**RE: Winrock Road B Extension
2100 Louisiana Blvd NE
Grading and Drainage Plan
Engineer's Stamp Date: 11/9/18
Hydrology File: J19D058G**

Based on submittal received on 11/9/18, the Grading Plan cannot be approved for Site Plan for Building Permit until the following are corrected:

TITLE:	ROAD B ROAD B STORM DRAIN PLAN & PROFILE STA. 21+50.00 TO STA. 29+16.00
--------	---

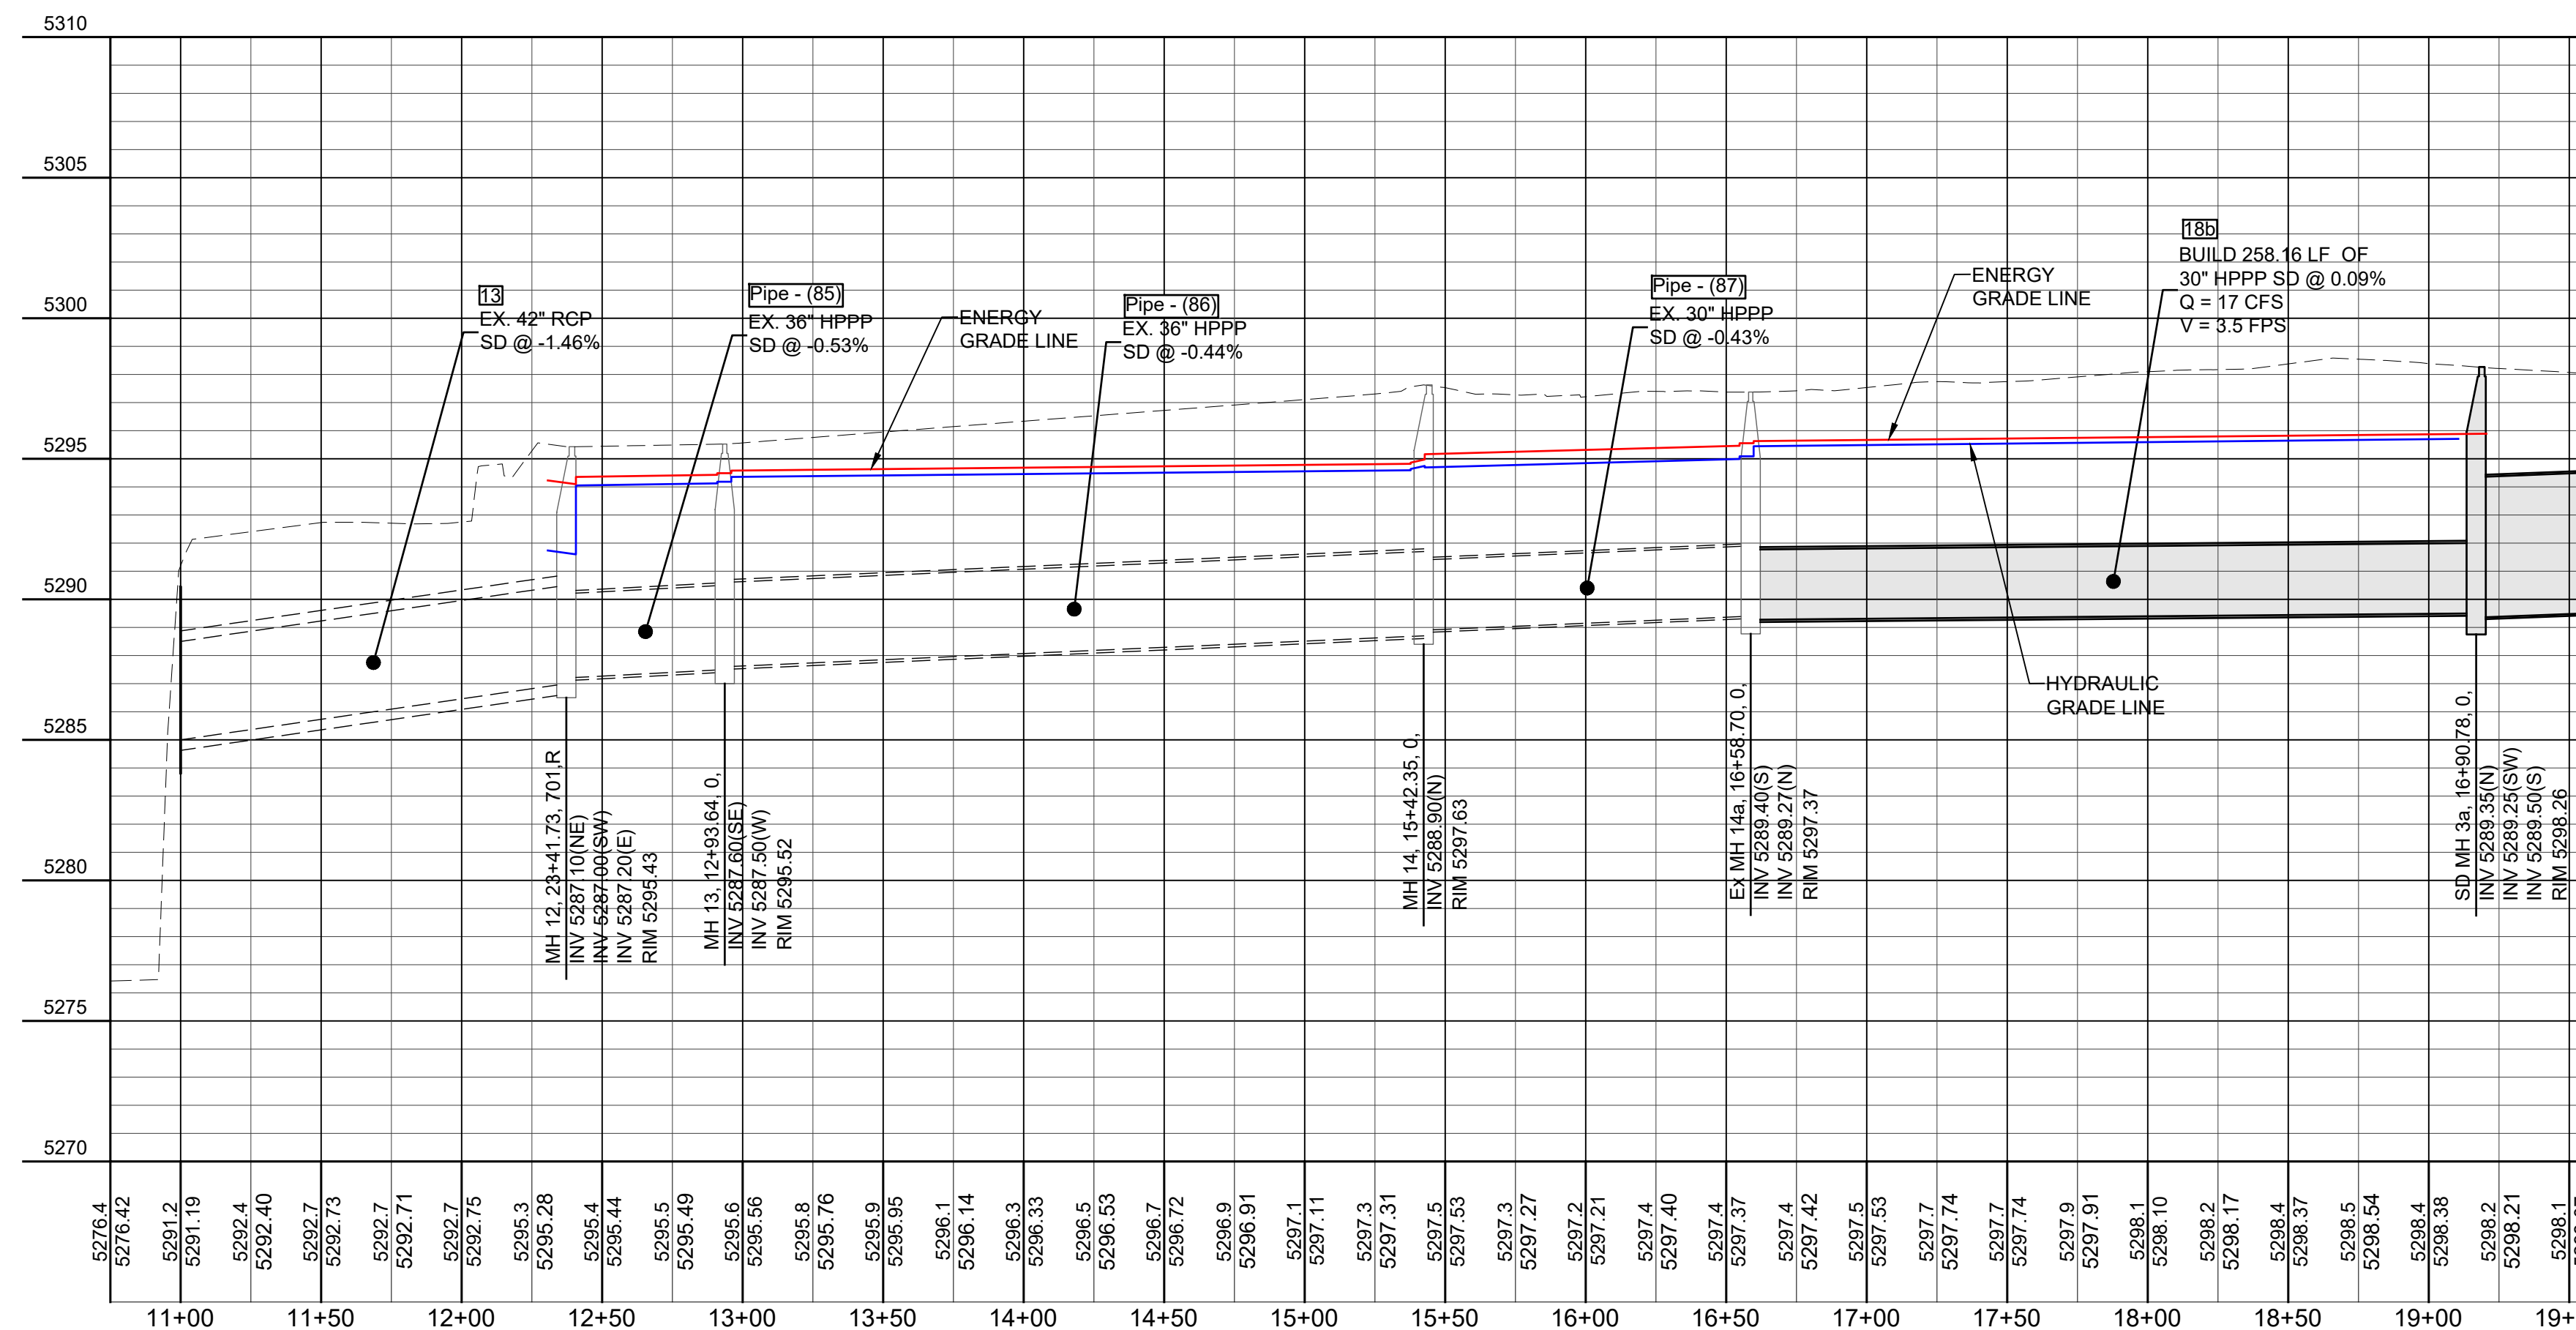
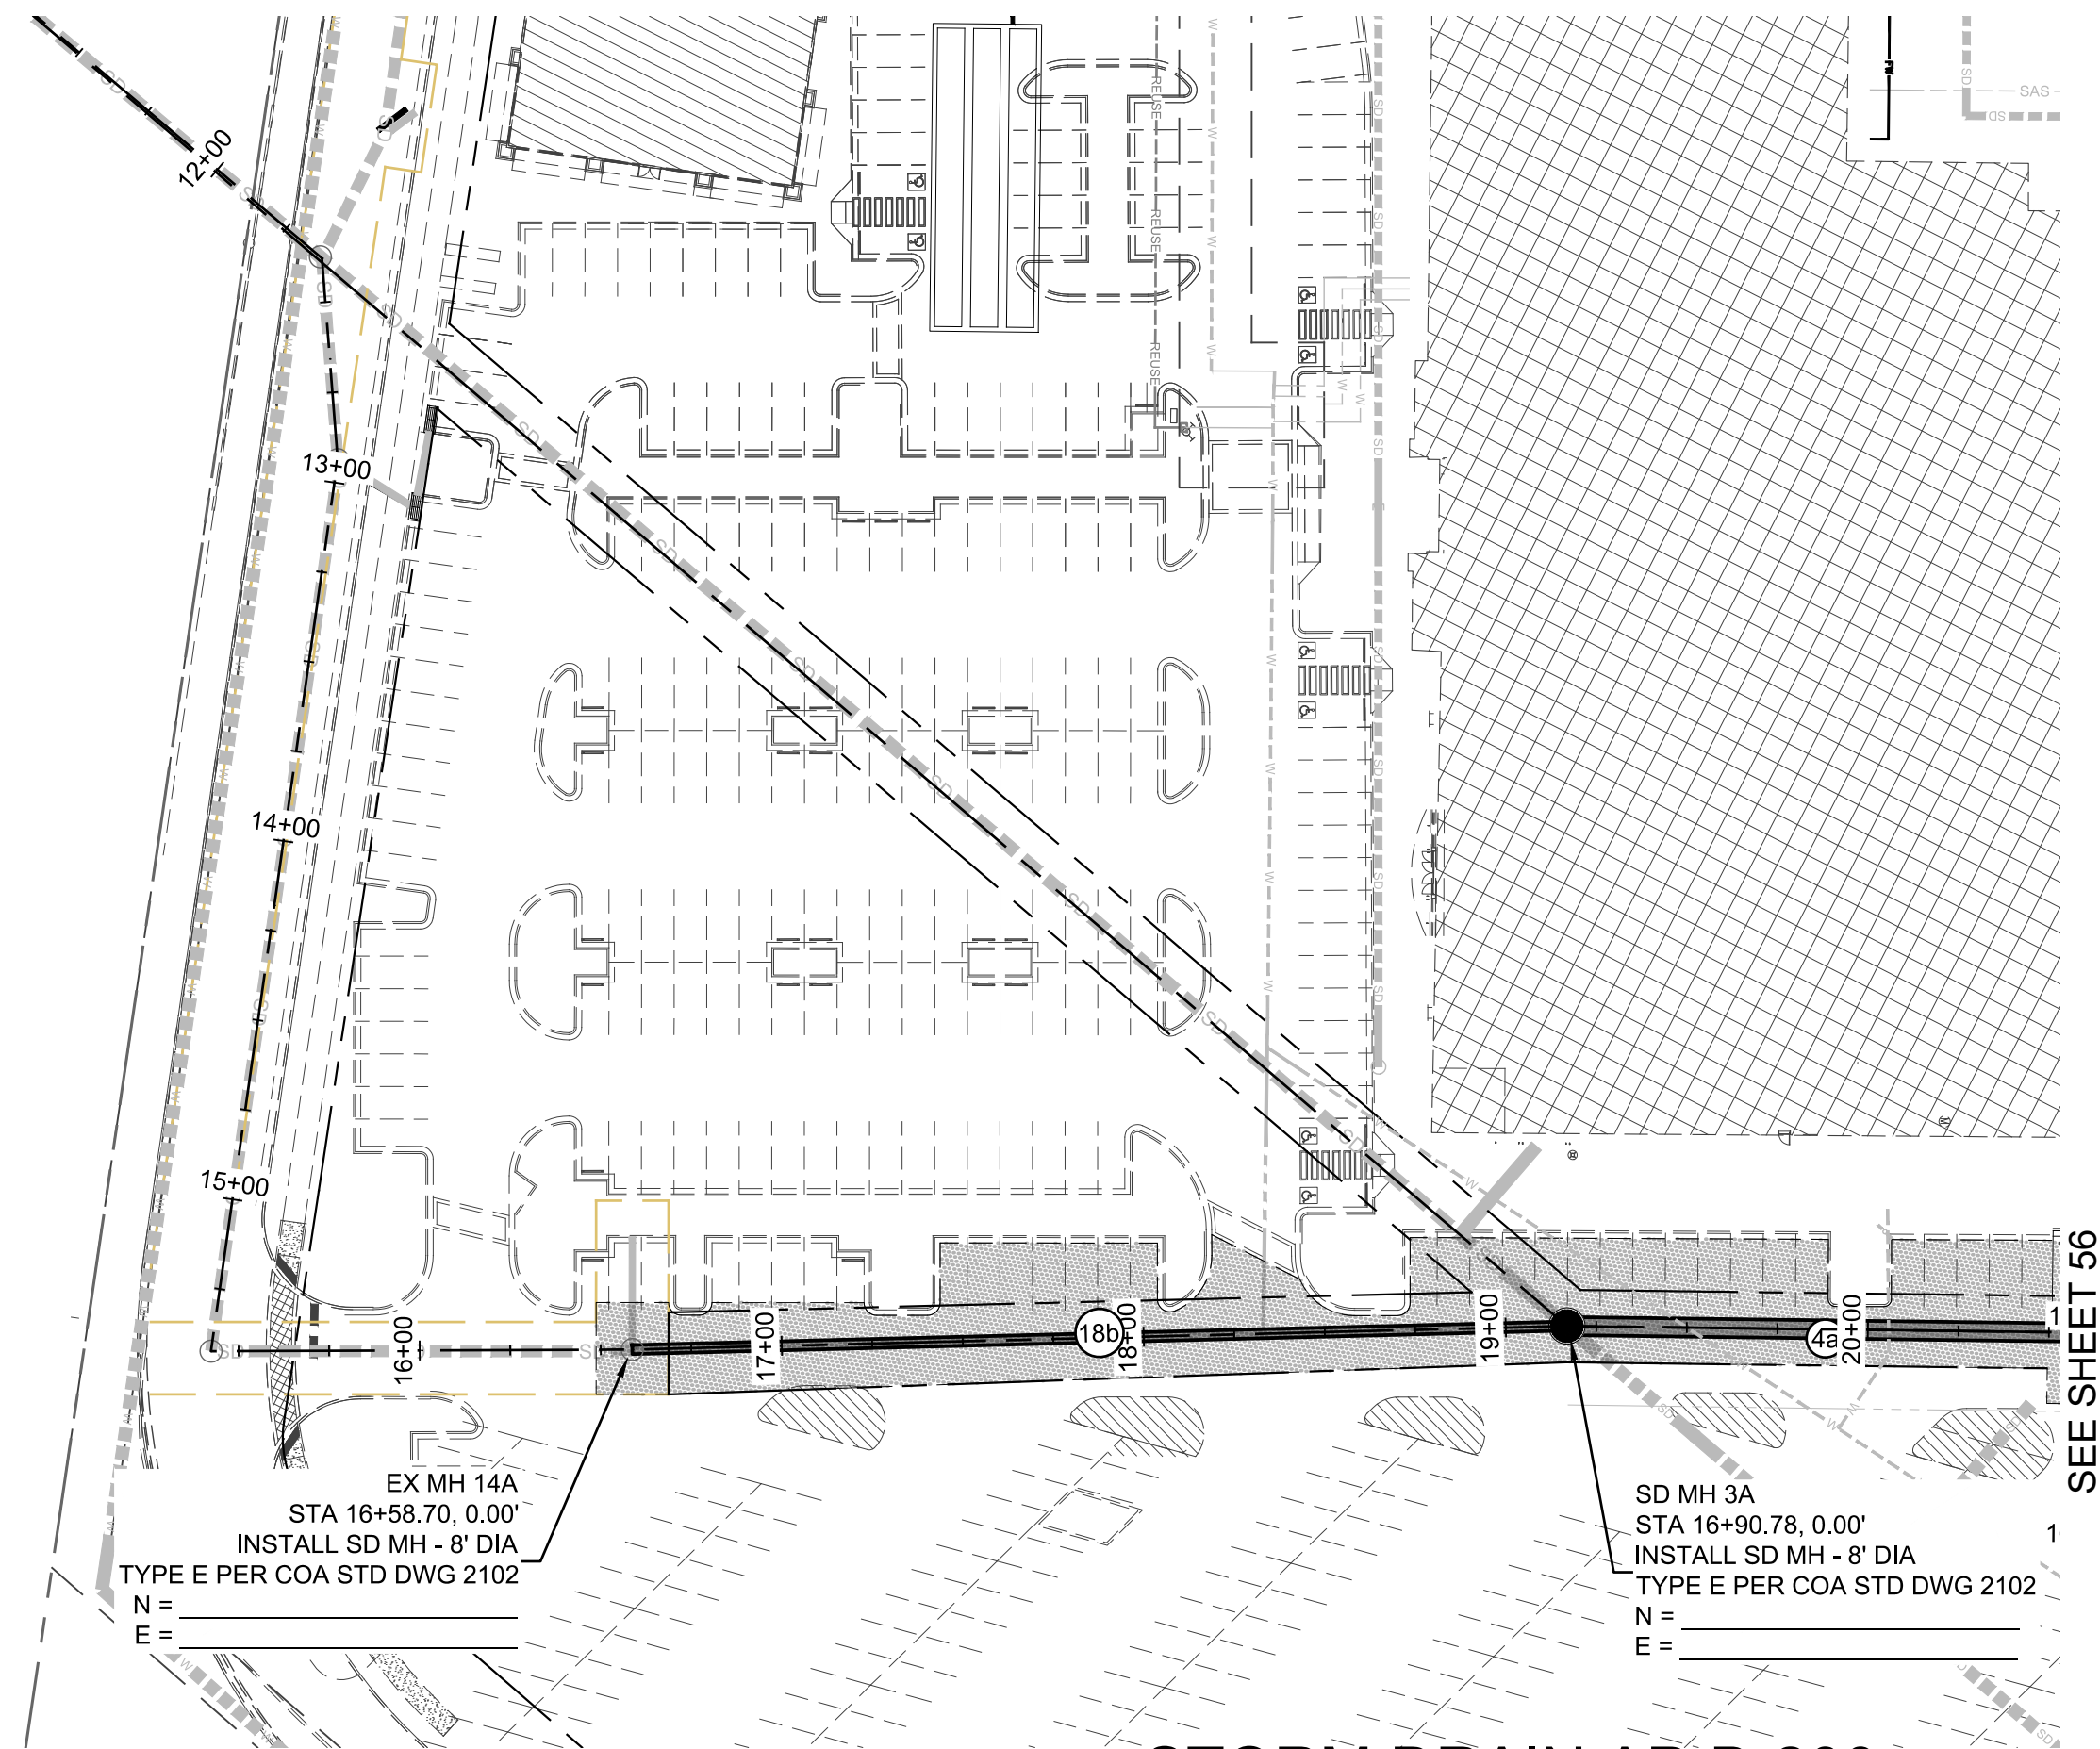
3. Show the proposed ROW. Describe what aspects of this project are public vs. private? Who will maintain what?
4. Provide stormdrain details: build notes, inverts, flow, pipe slopes, etc...
